Subject: FW: Planning Consultation on FP/42/19/DOC

Comment from Greenspace

The information supplied in Yes Landscape Consultants Soft Landscape Concept Dwg May 2018 is an indicative concept drawing and does not satisfy the detail required under Condition 12 which asks for a scheme of landscaping hard and soft to be submitted along with existing vegetation and protection measures to be employed. The information needs to be a detailed scheme in plan form with a suitable planting mix allowing for any mitigation and screening as may be required. The detail needs to include species type, actual numbers, planting densities and size at time of planting.

Project: Wellers Close Hampshire Homes Group	
Drawing: Soft Landscaping Concept	
Date: May 2018	Drawn by: JA
Scale: 1:200 @ A1	Revision: -

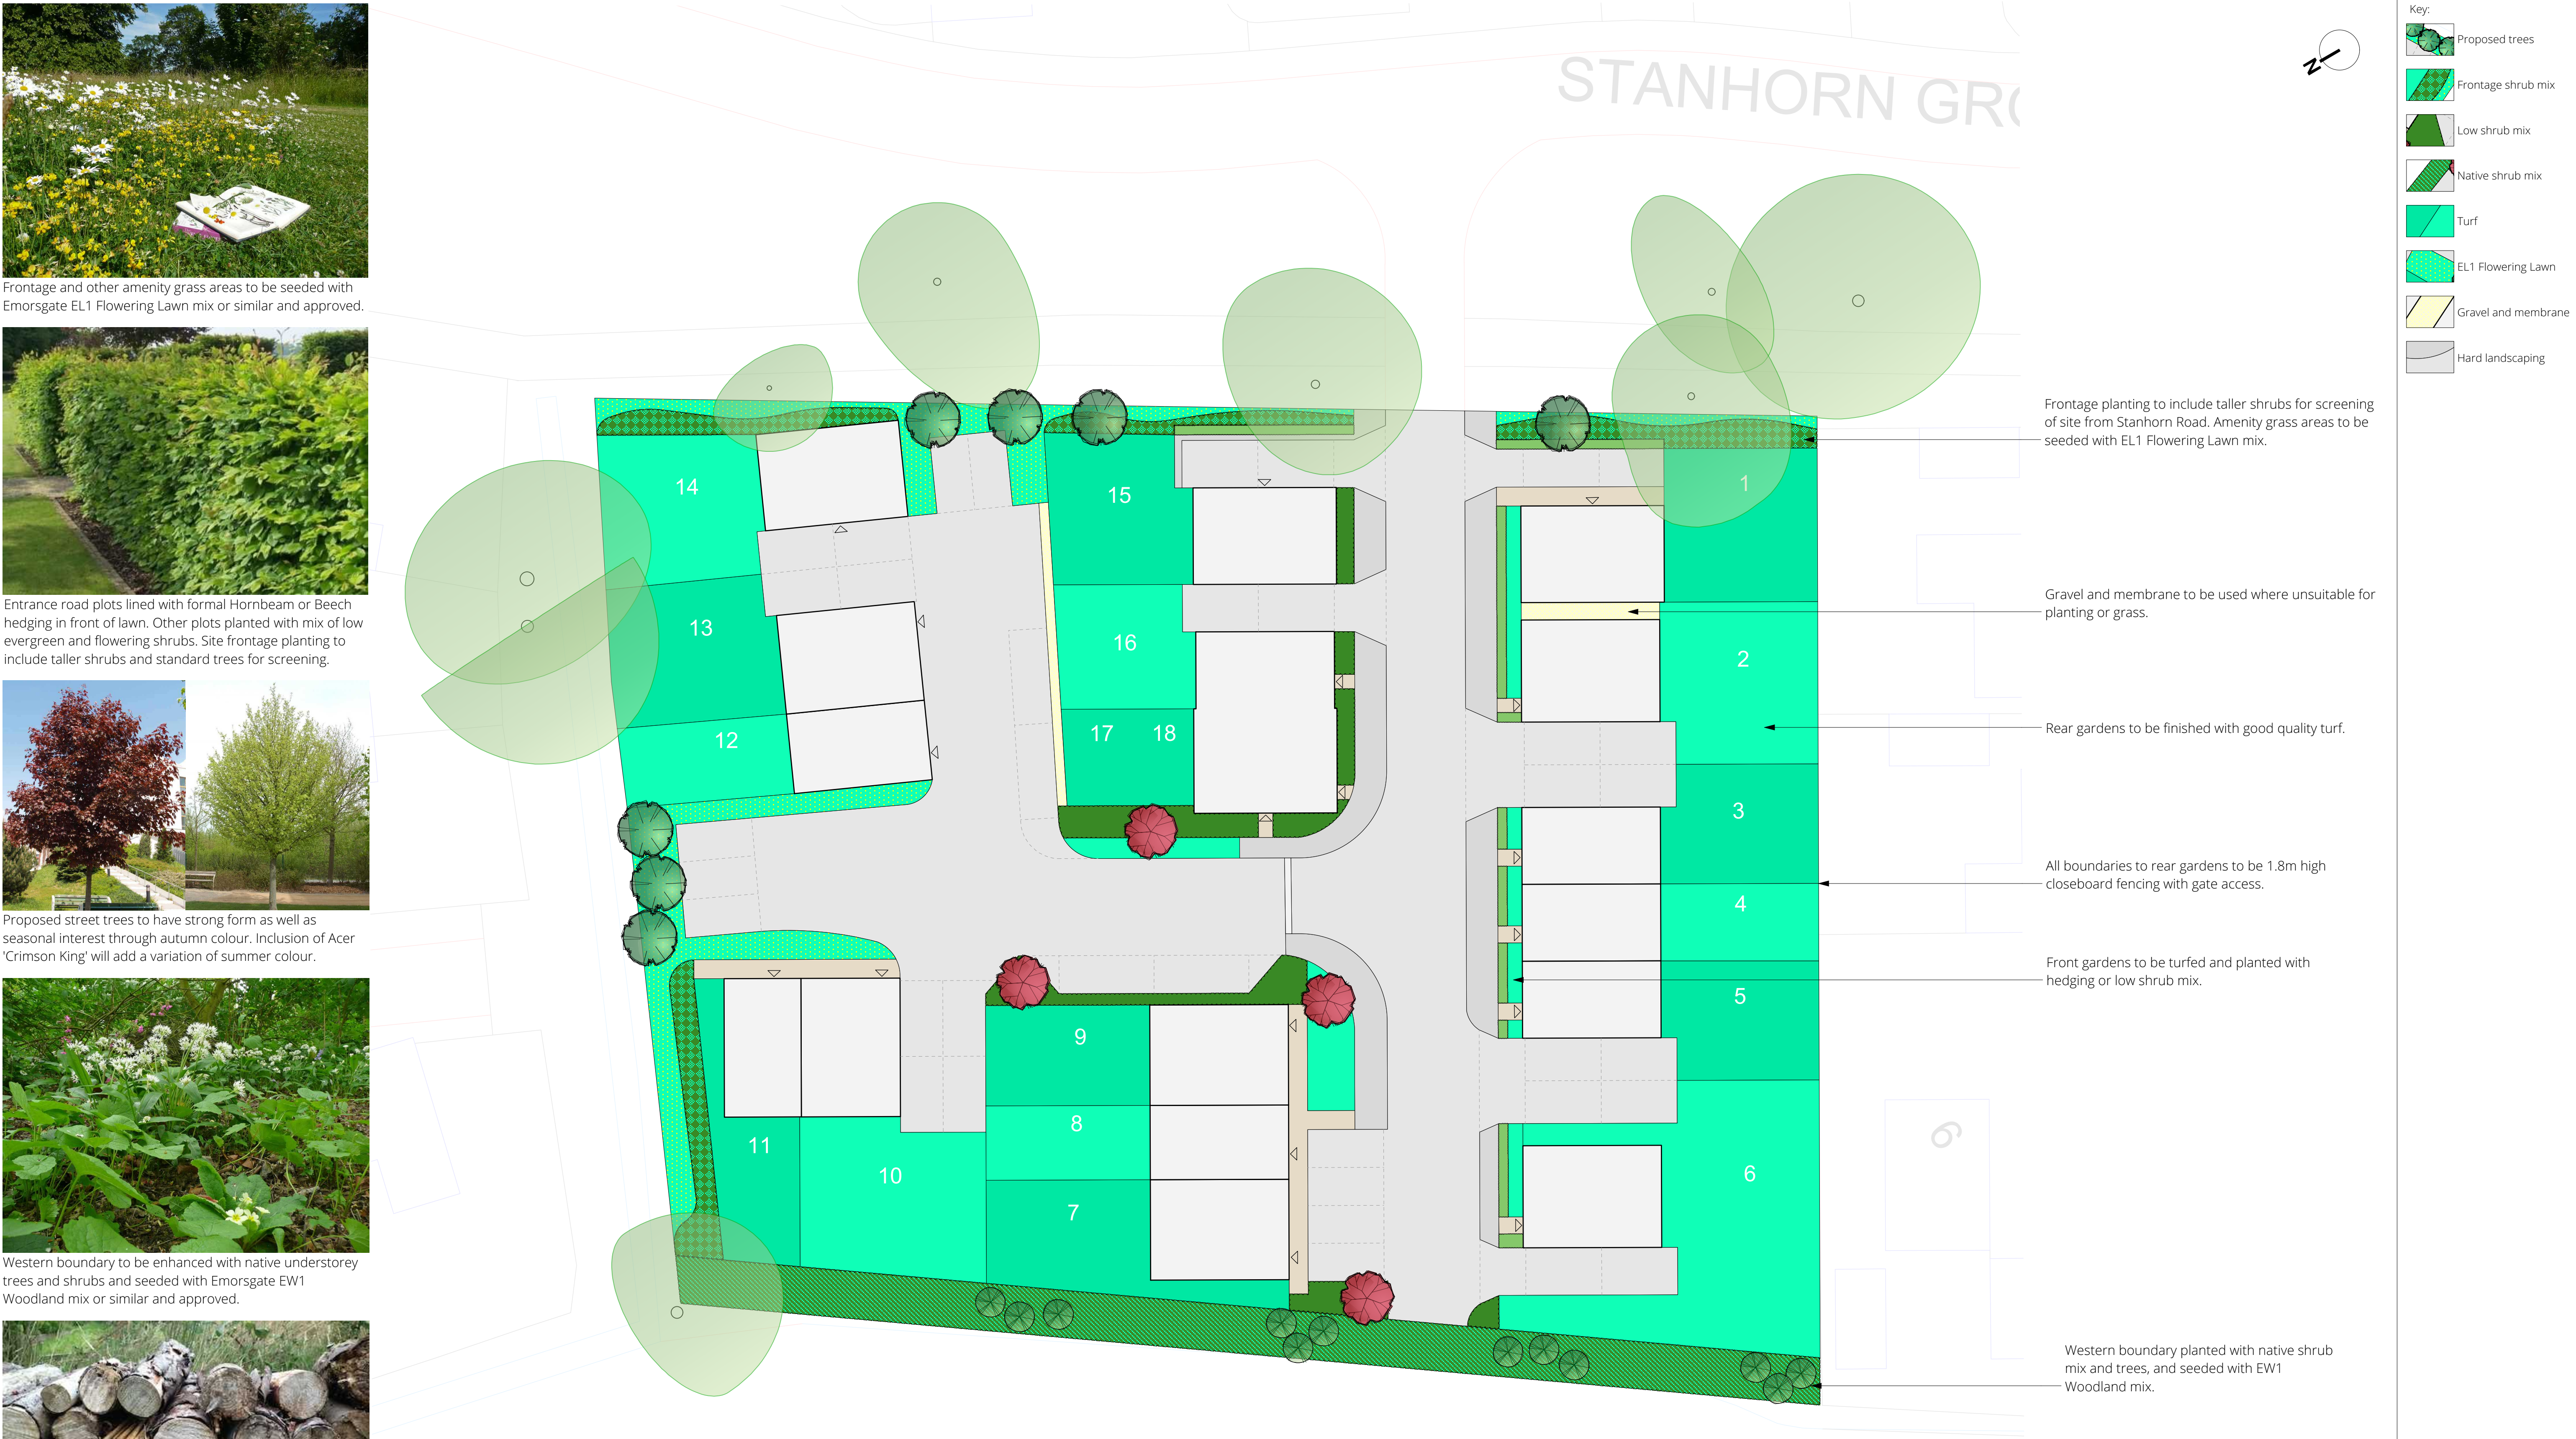
I would not recommend discharge of Condition 12 on this application FP/42/19/DOC imposed under FP/171/18/PL until this information is submitted for approval.
